From: Michael Wood [REDACTED]
Sent: 20 June 2019 15:27
To: Sian Eggington
Subject: RE: Further Information Required on Your Ref: PP-07926902 Our Ref: AW/184/19/HH

Please find attached our further revised drawing 853 PL02 Rev B as requested.

DRAWING TITLE
LOCATION PLAN, BLOCK PLAN AND SITE PLAN

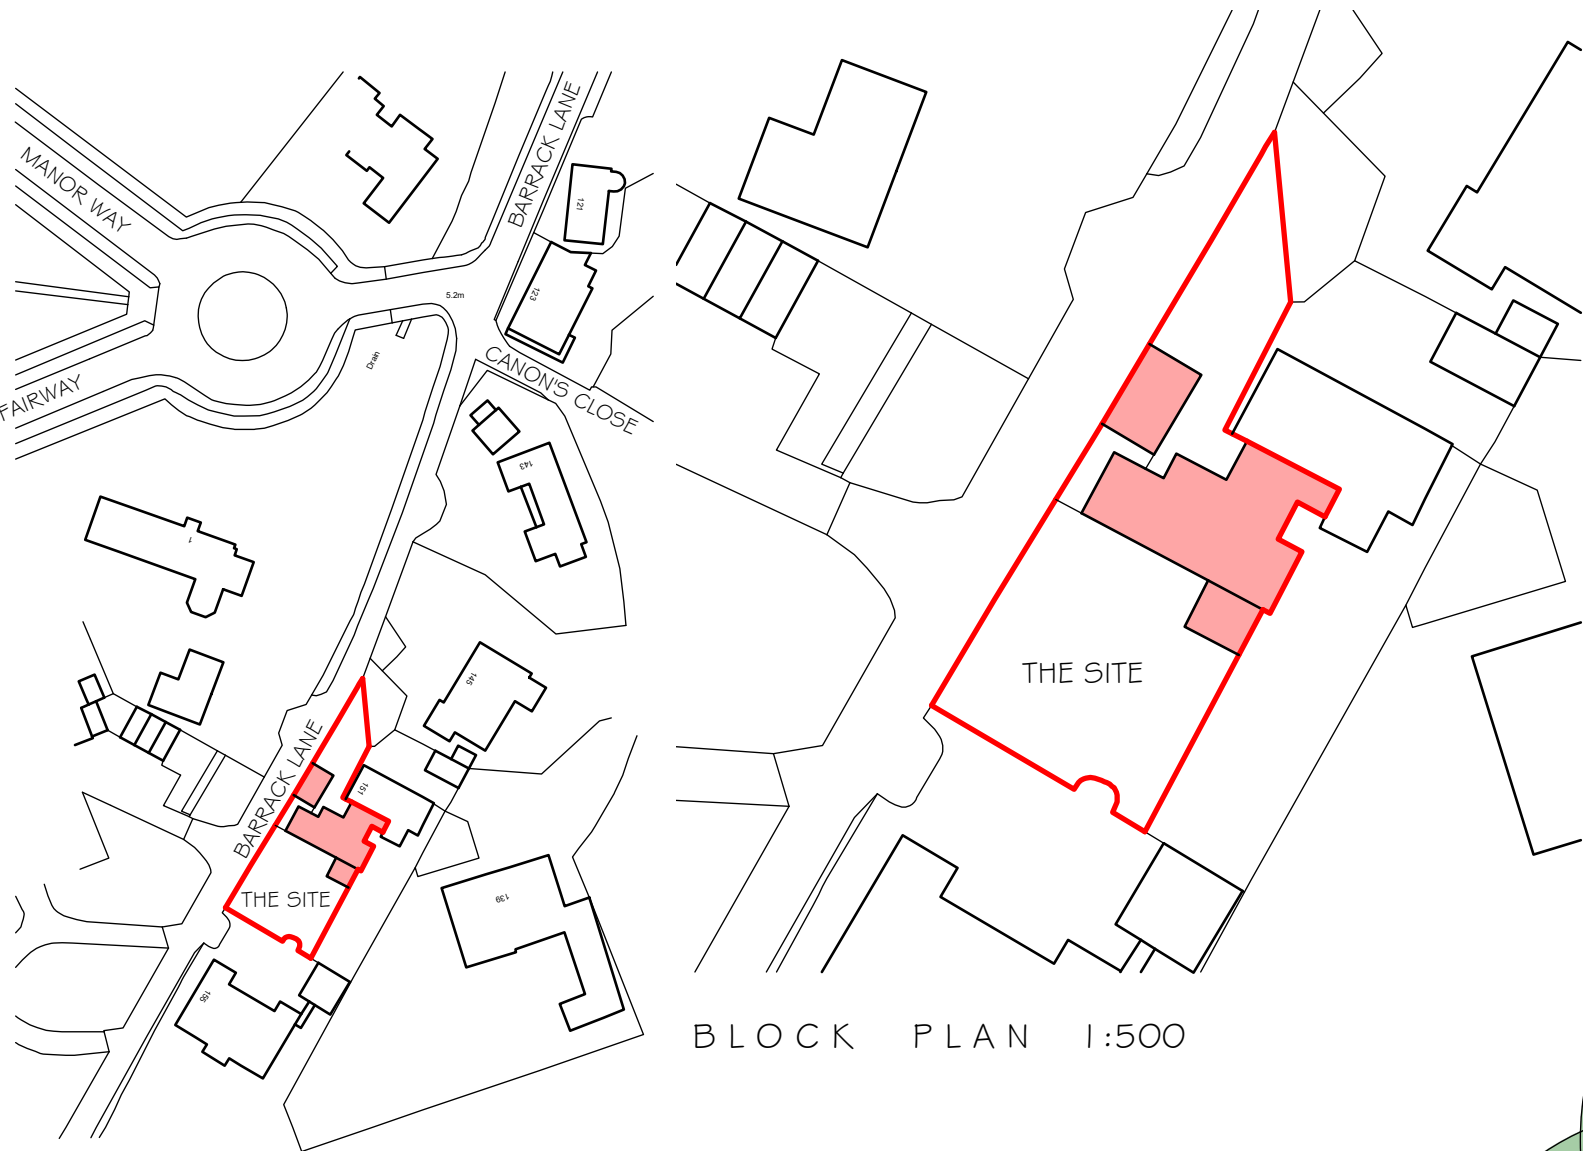
A dimension is required from the side extension to the rear boundary. Accordingly to my measurements it is around 17m from the side extension to the side boundary.

A dimension is also required from the proposed garden room to the front boundary this is measuring at around 12m.

Another from the garden room to the main dwelling measuring at around 8m. And finally one from the porch to the other side boundary is measuring in at 14m
